1 No new dwelling & detached hydrotherapy pool house along with associated external works & creation of 1 No additional vehicular entrance.

Ferringham House 58 Ferringham Lane Ferring

Thank you for your internet representation made on 2nd May 2020 which has been recorded as '**an objection**' with the comments as follows:

Hydro Therapy Pool House Elevations As Proposed

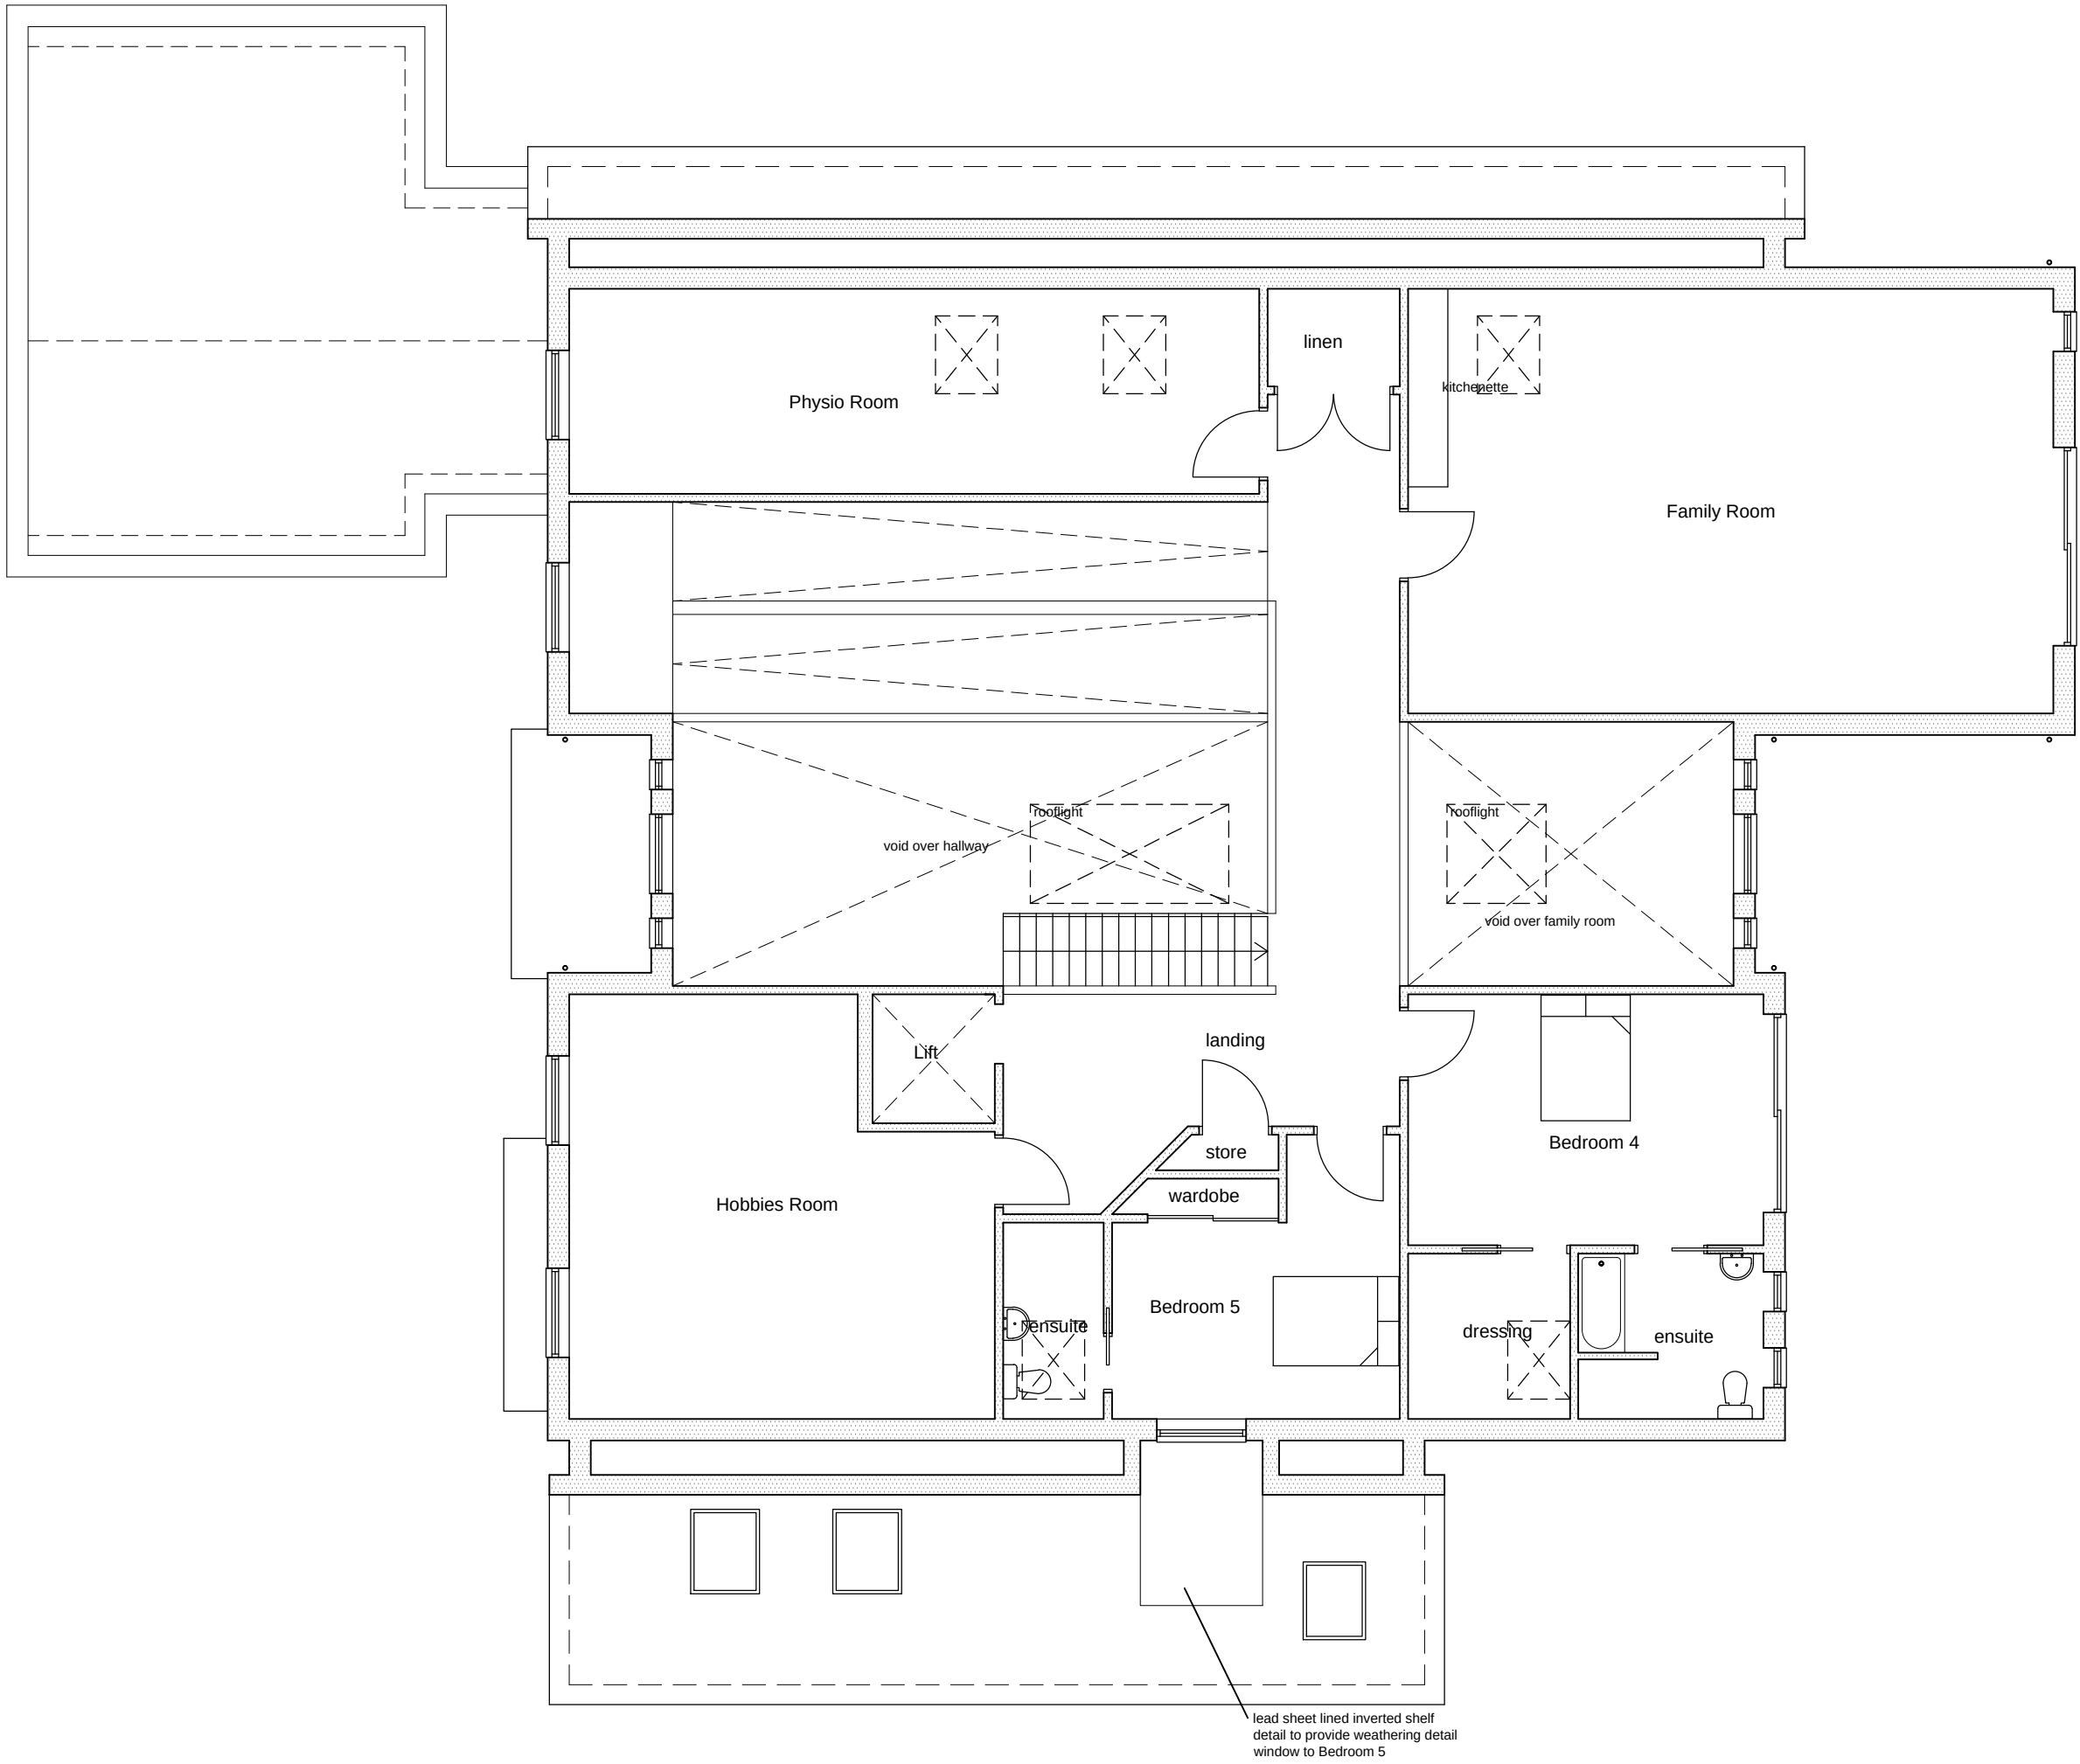
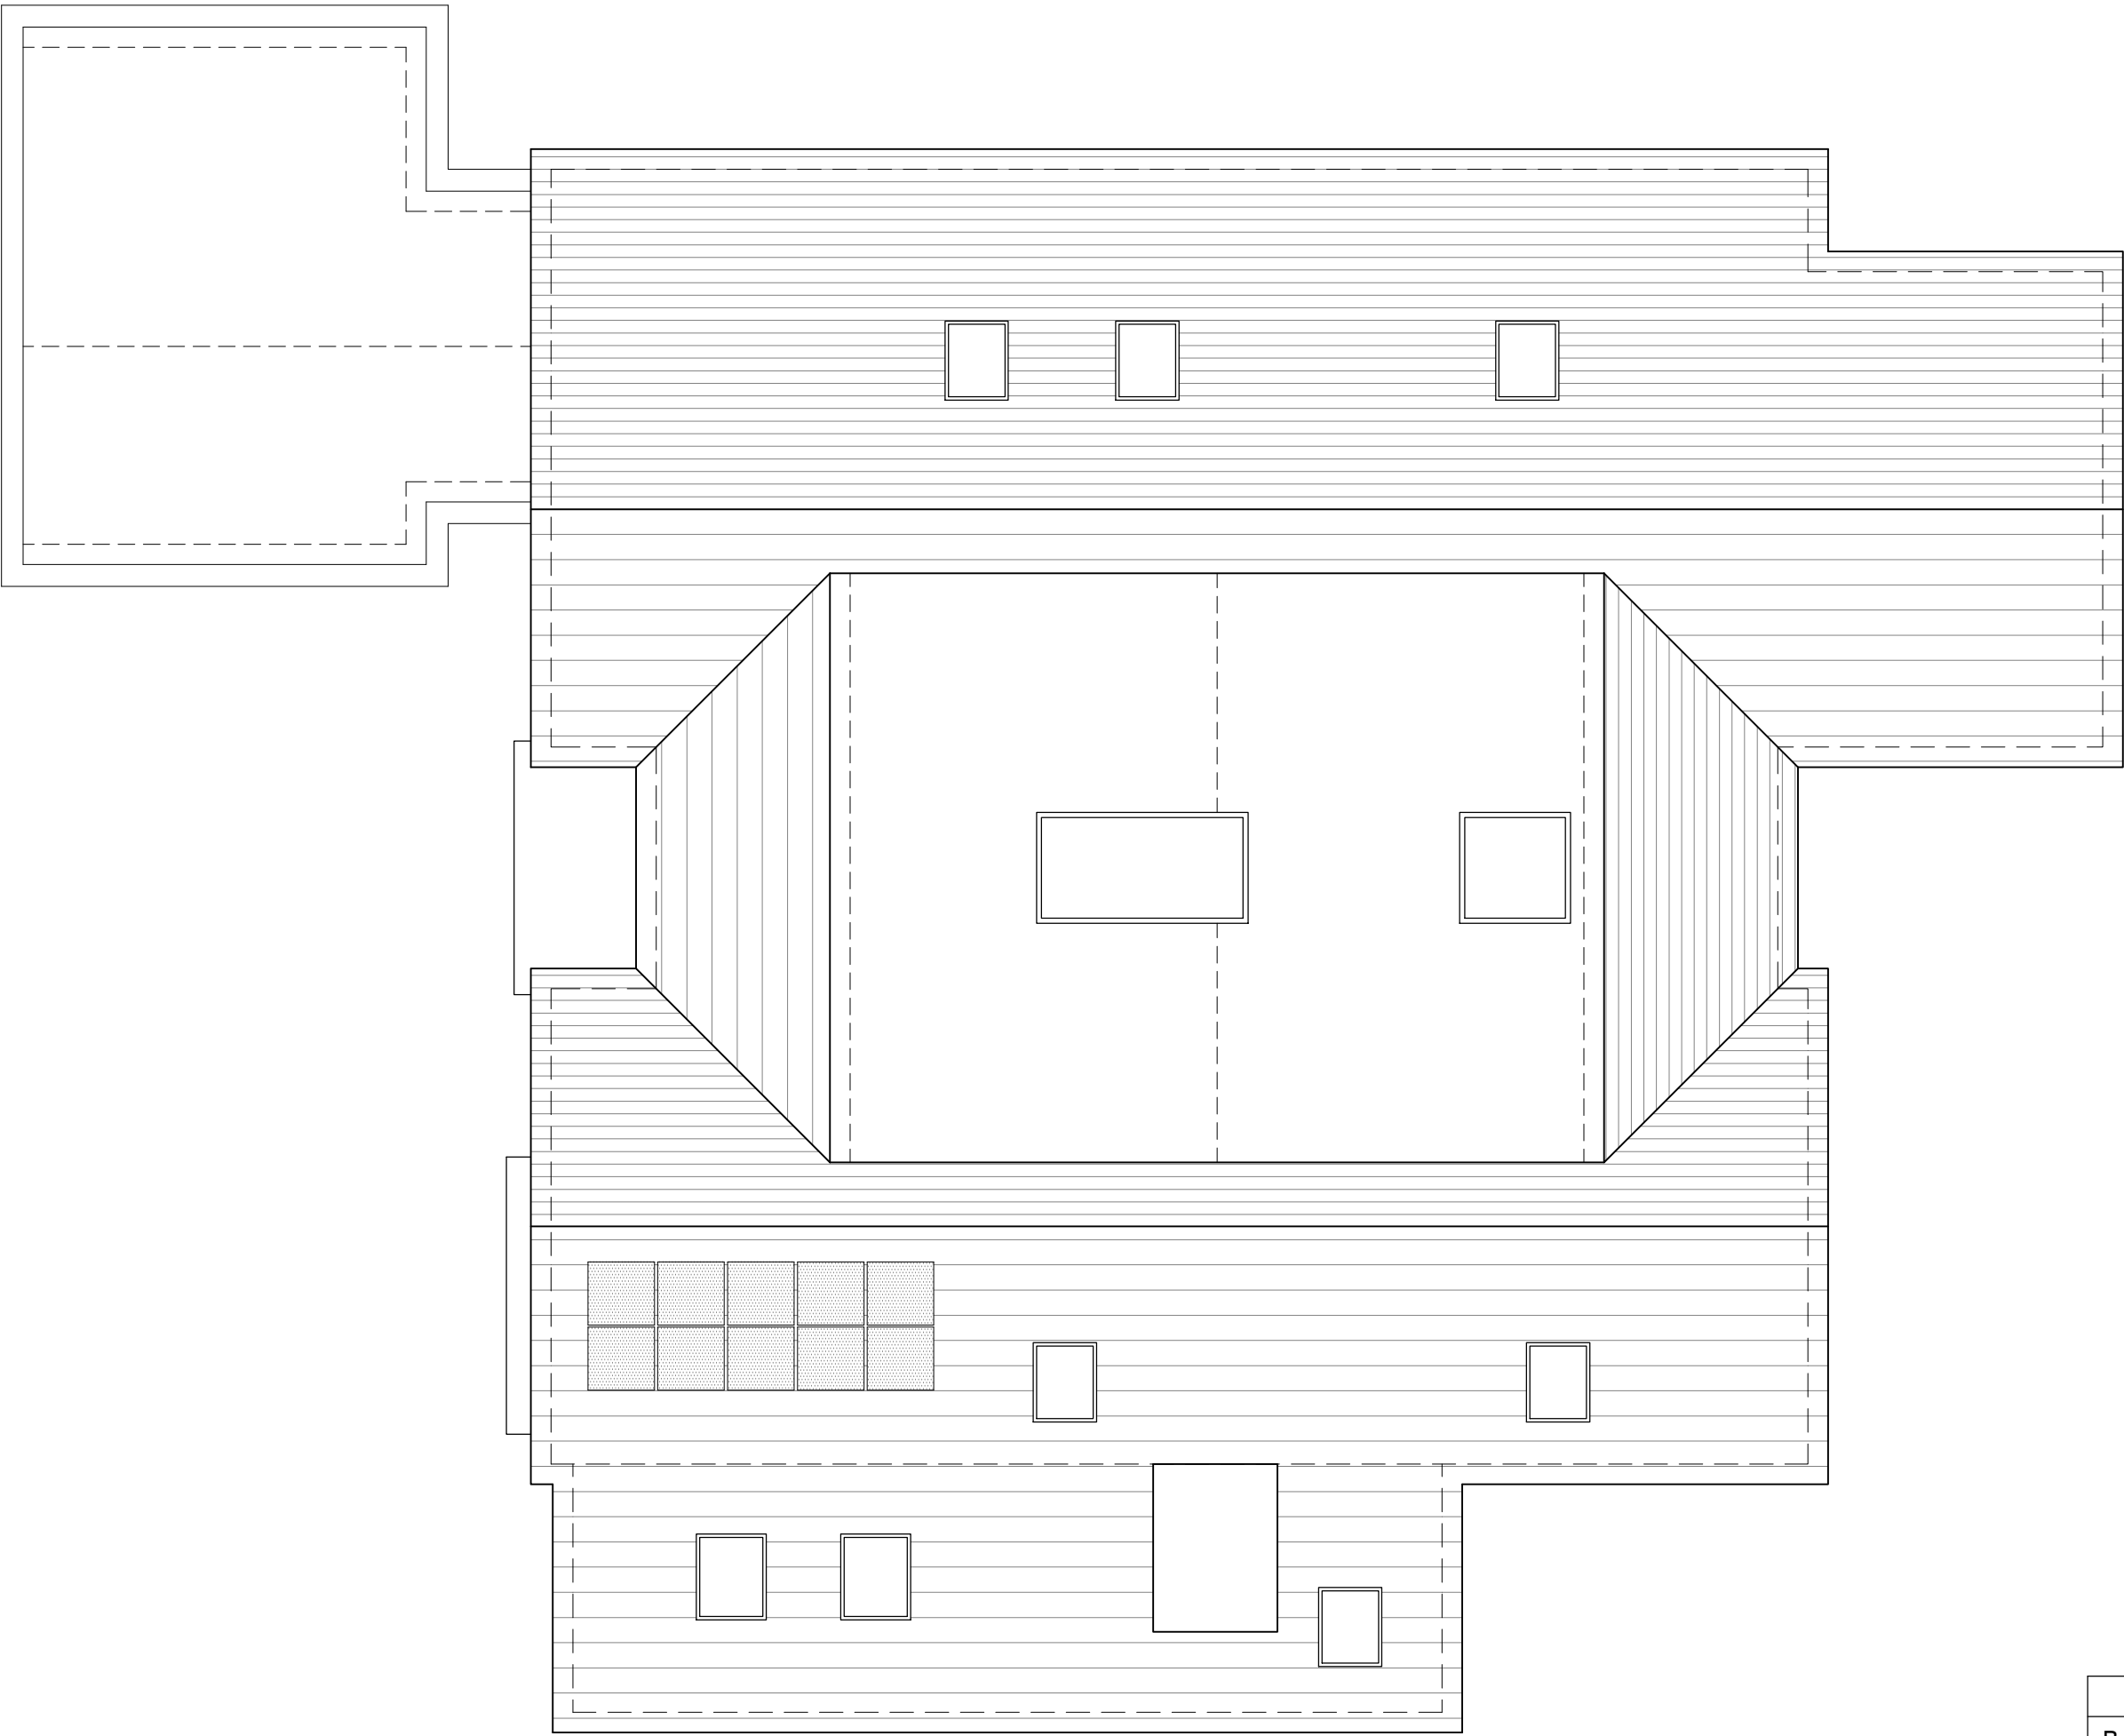
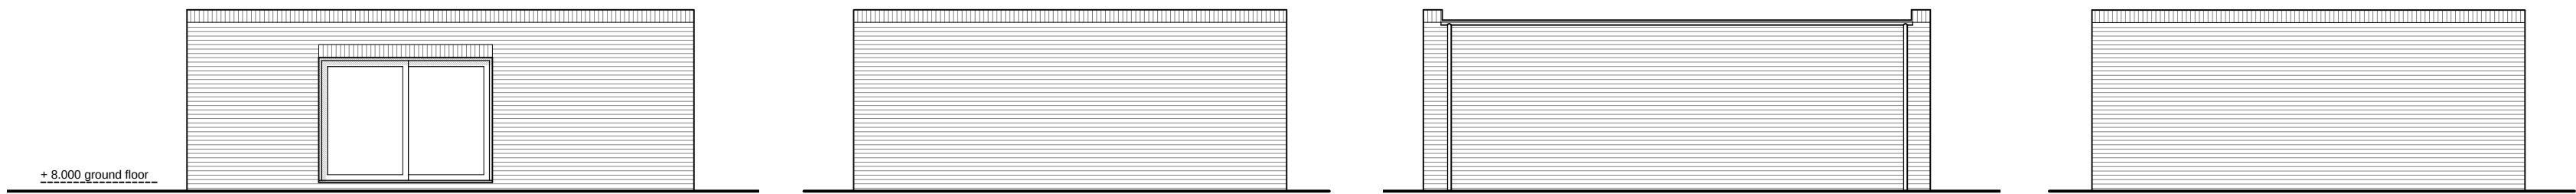
The Design and Access statement however does not provide a rationale for the design of the proposed detached hydropool house.However it does appear that the benefits of a hydropool could be achieved and with better access if the pool was attached to the main dwelling rather than located at the bottom of the garden.

(2)From studying the plans,the pool house would be sizeable with a footprint of 66sq.m and a height of 3.15m.The poolhouse would be just 0.4m from the boundary to our property and patio area,it would be 1.35m taller than the boundary fence and only 4.5m from our kitchen patio door.This would be over-bearing,causing loss of light and amenity to our kitchen patio doors and external garden patio area.

In summary we are sympathetic to the proposal but have concerns about the location and height of the poolhouse.
